### VISTA WEST PERFORMANCE BASED CLUSTER PLAT

TO: Kittitas County Hearing Examiner  
FROM: Kittitas County Community Development Services Staff  
RE: Vista West Performance Based Cluster Plat (LP-09-01)  
DATE: December 9, 2010

VISTA WEST
PERFORMANCE BASED CLUSTER PLAT
A PTN. OF THE NORTH 1/2 OF SEC. 33, T.20N., R.14E., W.M.
KITITAS COUNTY, WASHINGTON

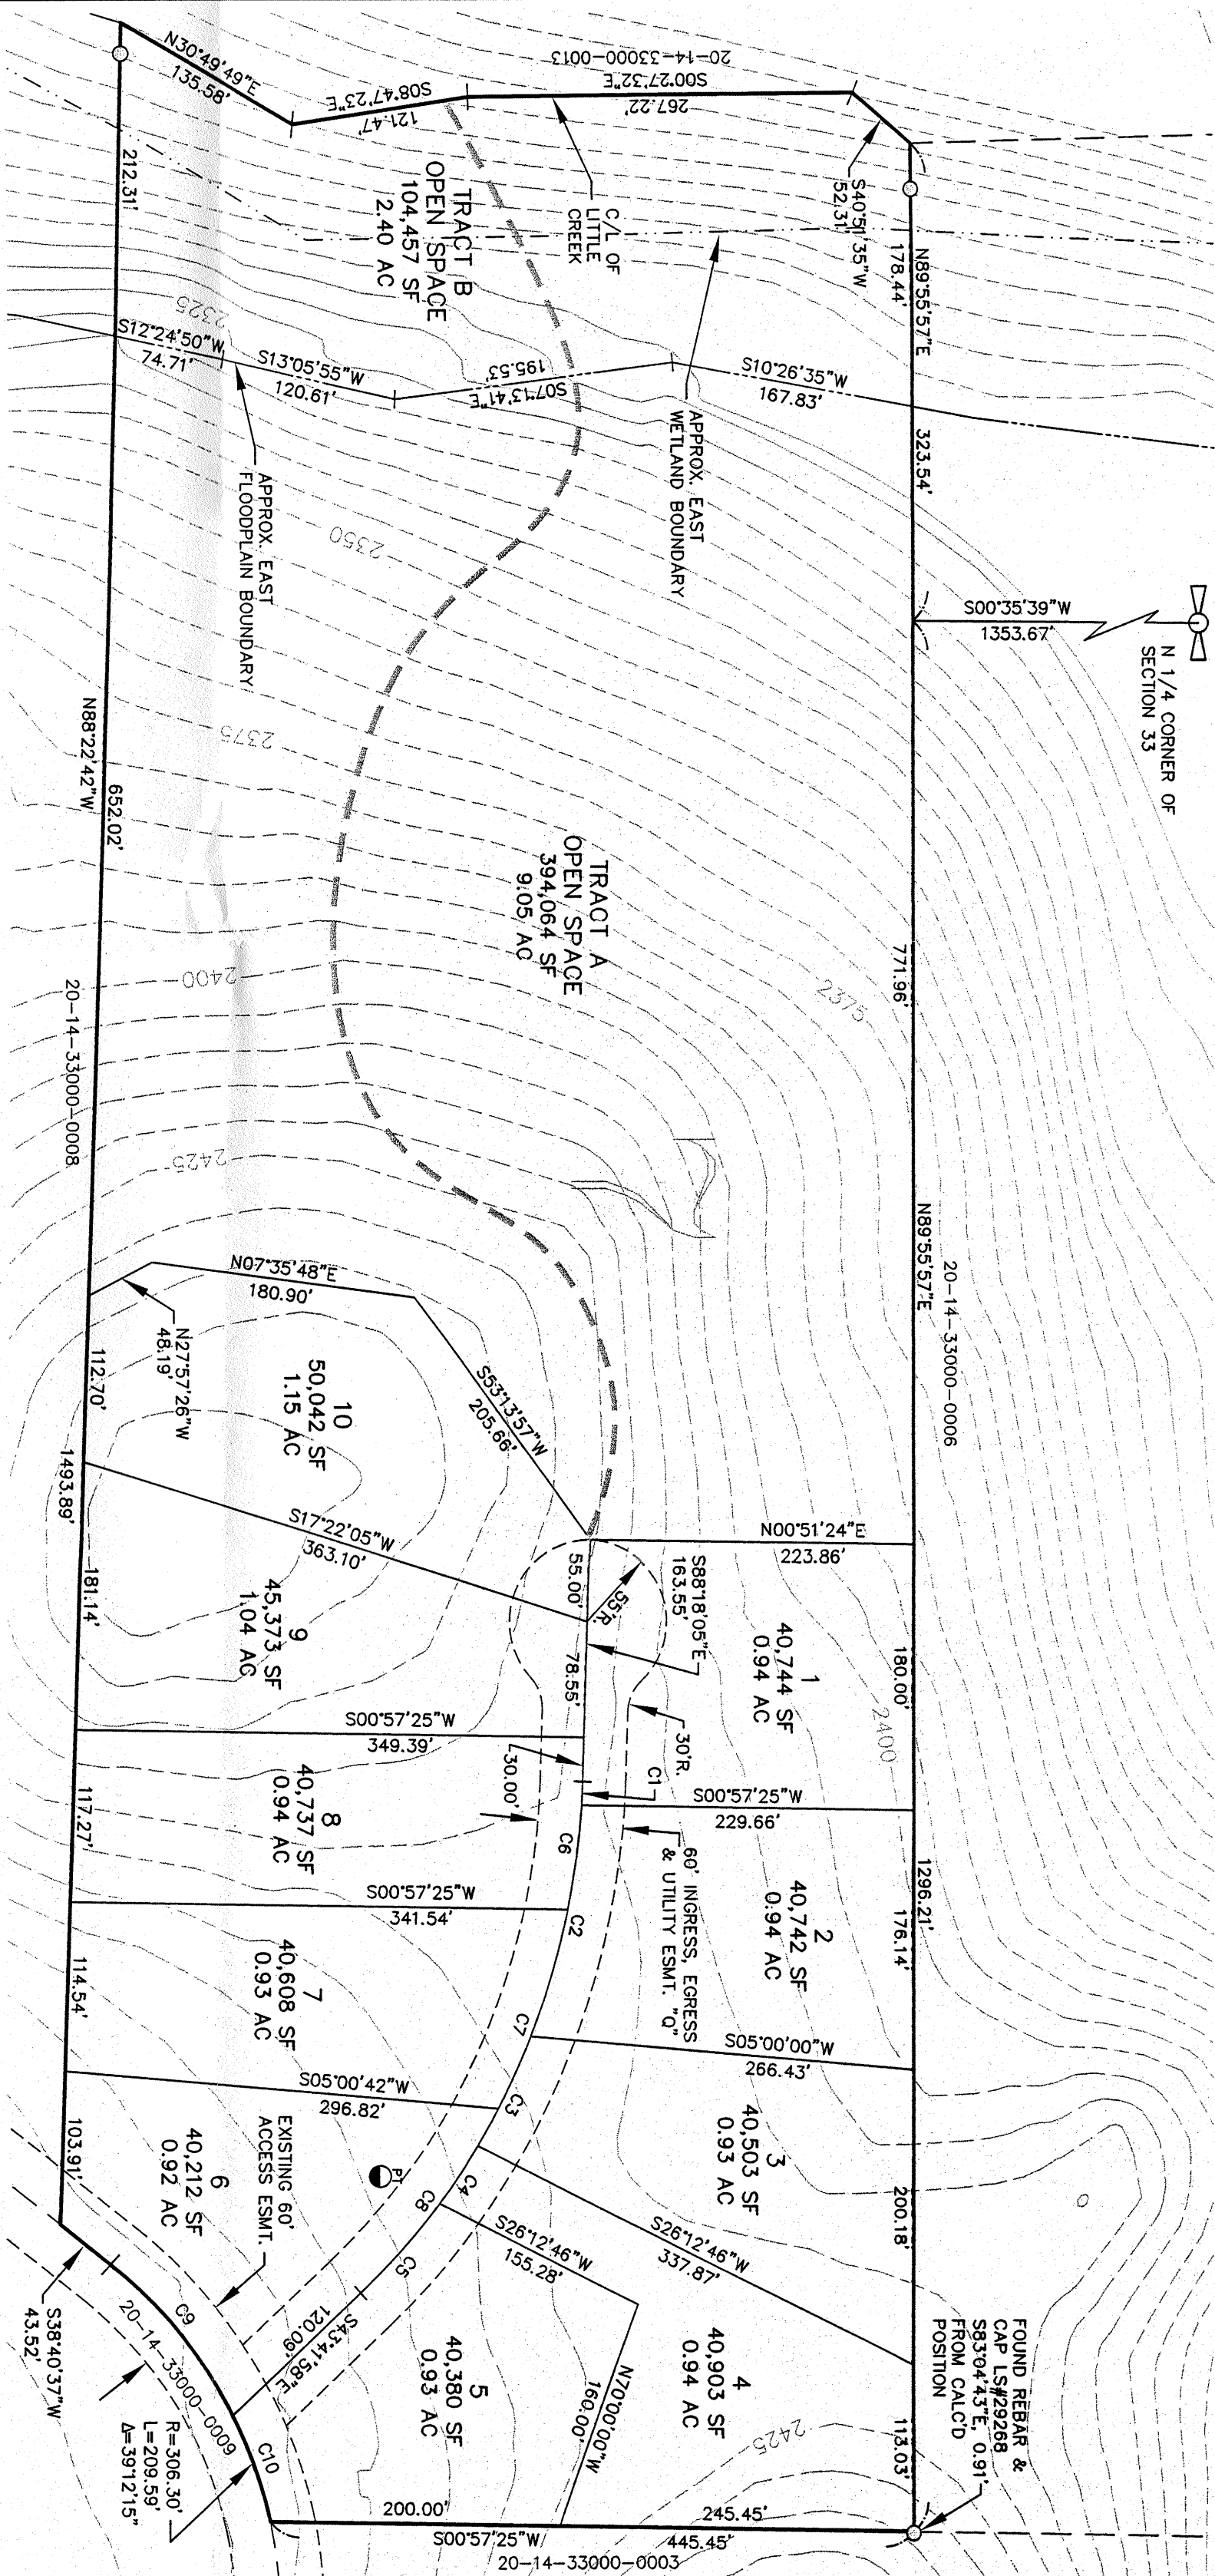
6. Wetland Impacts: The proposed plat area contains a wetland area along Little Creek. No development is proposed in this mapped wetland or within approximately 600 feet. The plat shows a trail passing through the wetland and across Little Creek, and notes this trail is possible for future construction "at the discretion of the owner." Construction of this trail will require compliance with Title 17A Critical Areas.

7. Flood Prone Areas: The project site contains frequently flooded areas associated with Little Creek, which is under the jurisdiction of the County's Shoreline Master Program. No lots are proposed within the floodplain boundary, but a trail for possible future construction is shown. Any development within floodplain associated with Little Creek is subject to 17A.05.020 "No net loss of floodplain storage" and applicable provisions of the Conservancy environment included in the Shoreline Master Program.

8. Future Trail Construction: The following note shall be placed on the face of the final plat:

*The approval of CL-09-00001 does not authorize construction of the proposed trail system noted as "future construction at the discretion of the owner." The proposed trail passes through a wetland, floodplain, and "Conservancy" shoreline environment. Trail construction shall be subject to County review and approval for compliance with Title 17A Critical Areas and the Shoreline Management Program, and additional wetland and flood storage analysis may be required prior to trail construction.*
